**From:** Tom Errico <thomas.errico@tylin.com>  
**To:** Jean Fraser <JF@portlandmaine.gov>  
**CC:** David Margolis-Pineo <DMP@portlandmaine.gov>, "Earley, Katherine" <KAS@portlandmaine.gov>, Jeremiah Bartlett <JBartlett@portlandmaine.gov>, "Tarling, Jeff" <JST@portlandmaine.gov>  
**Date:** 2/3/2016 4:59 PM  
**Subject:** **31 Fore Street - Traffic Comments**

Jean - I have reviewed the project application and generally find it to be acceptable with the following comments.

DRAWING NO.
C-10

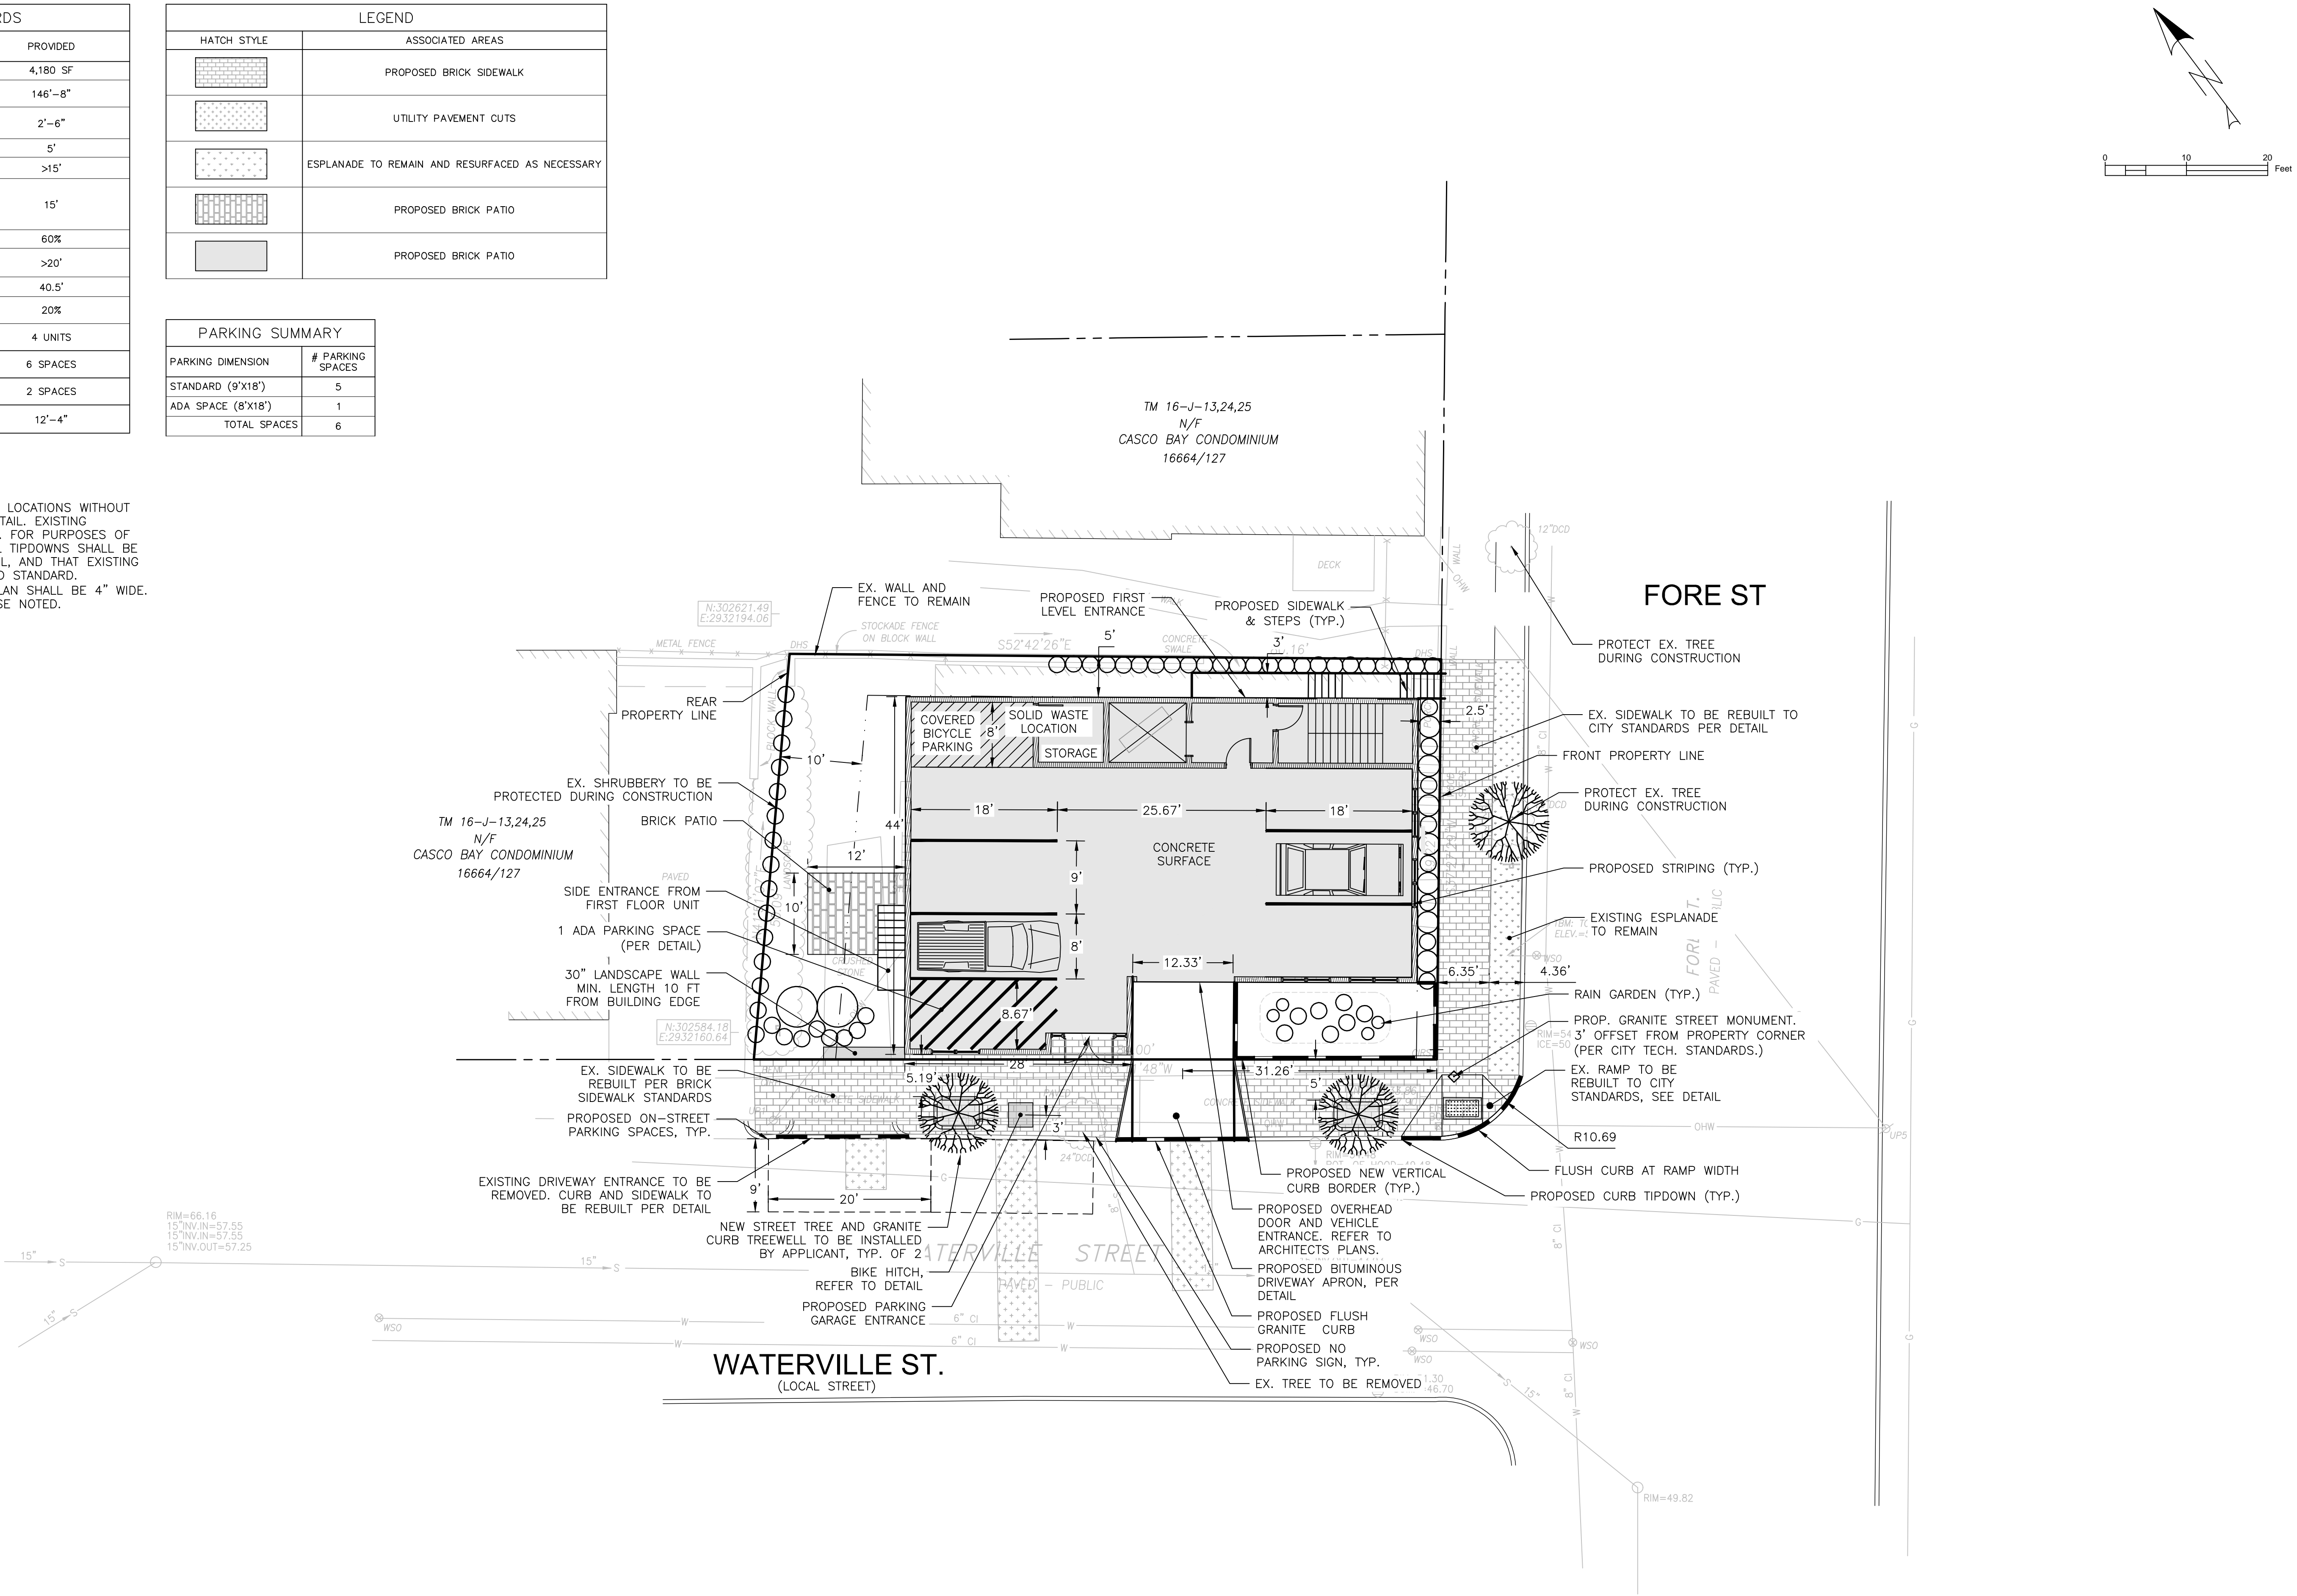
- \* The proposed project does not meet City standards as it relates to corner clearance. City standards require 35 feet of clearance, and the project will be providing approximately 31 feet of clearance. Given that the project is providing a driveway on the lower volume street (not on Fore Street), providing increased separation with a nearby driveway, and site design factors, I find the driveway location to be acceptable and I support a waiver from City standards.

- \* The aisle width for the parking lot is slightly wider than City standards. I support a waiver from City standards.
- \* The applicant shall provide a construction management plan for review and approval.
